Nationally Significant Infrastructure Project: EN010159 – One Earth Solar Farm

**Response to The Examining Authority's written questions and requests for information
(ExQ1) issued on 7 August 2025**

Prepared by Lincolnshire County Council (LCC)

August 2025

Figure 2.1: Illustrative Layout West BESS

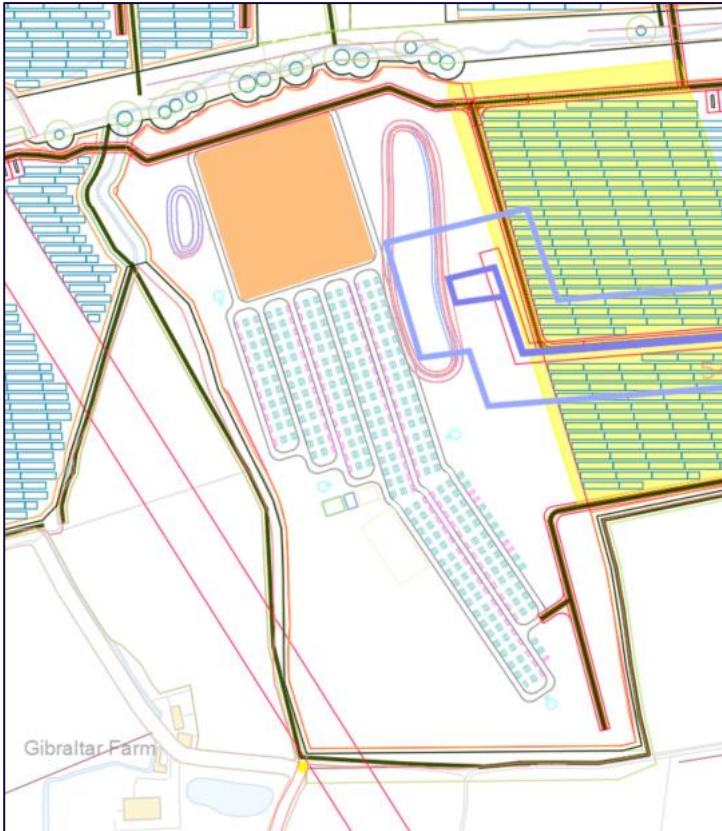
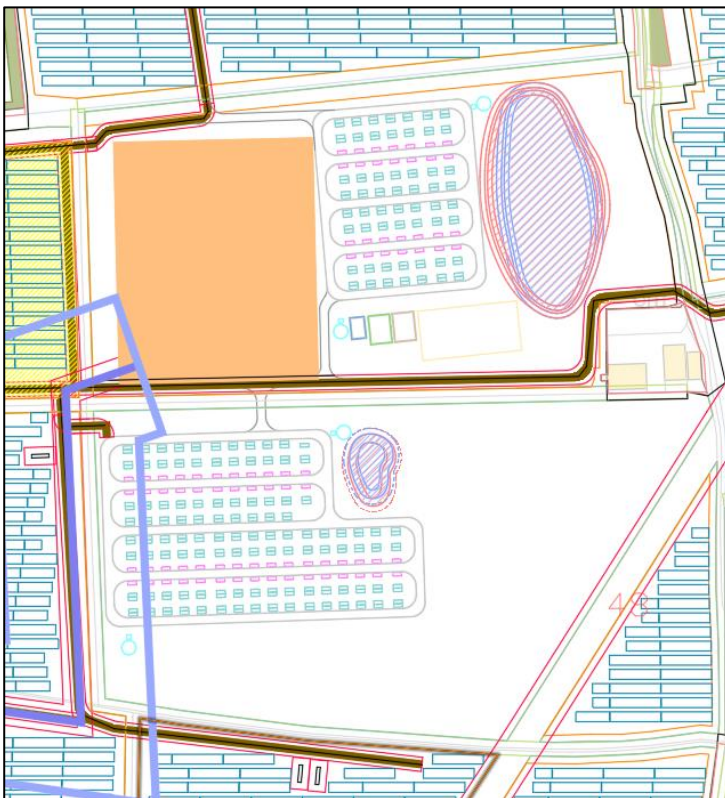
<ul style="list-style-type: none"> - OBSMP States – <i>“BESS will be separated from the site boundaries by a minimum of 25m prior to any mitigations”</i> – No further details are provided and as such site plans will need to be confirmed - OBSMP Requirement – <i>“Emergency Plans including Risk Management and Emergency Response Plans (ERP) shared with the FRS”</i> – Document states – <i>“An ERP shall be developed in consultation with the local FRSs and include information to assist operators and firefighters in an effective fire response. These shall be reviewed and updated regularly. A risk management plan shall be developed, see Section 4.7 for details”</i> All relevant topics are outlined, but LFR reserve the right to comment and ensure plans are suitable and sufficient. - Section 4 General – Acknowledges that the developer will need to continue to engage with LFR as the development progresses and further information is made available – LFR retain the right to object as further specific details are submitted <p>LFR will require further details on battery technology as plans develop to support on-going engagement and development of emergency plans and procedures.</p> <p>All remaining areas appear compliant at this stage of the development, but again recognise site plans are indicative, with further details required for LFR to acknowledge compliance.</p>
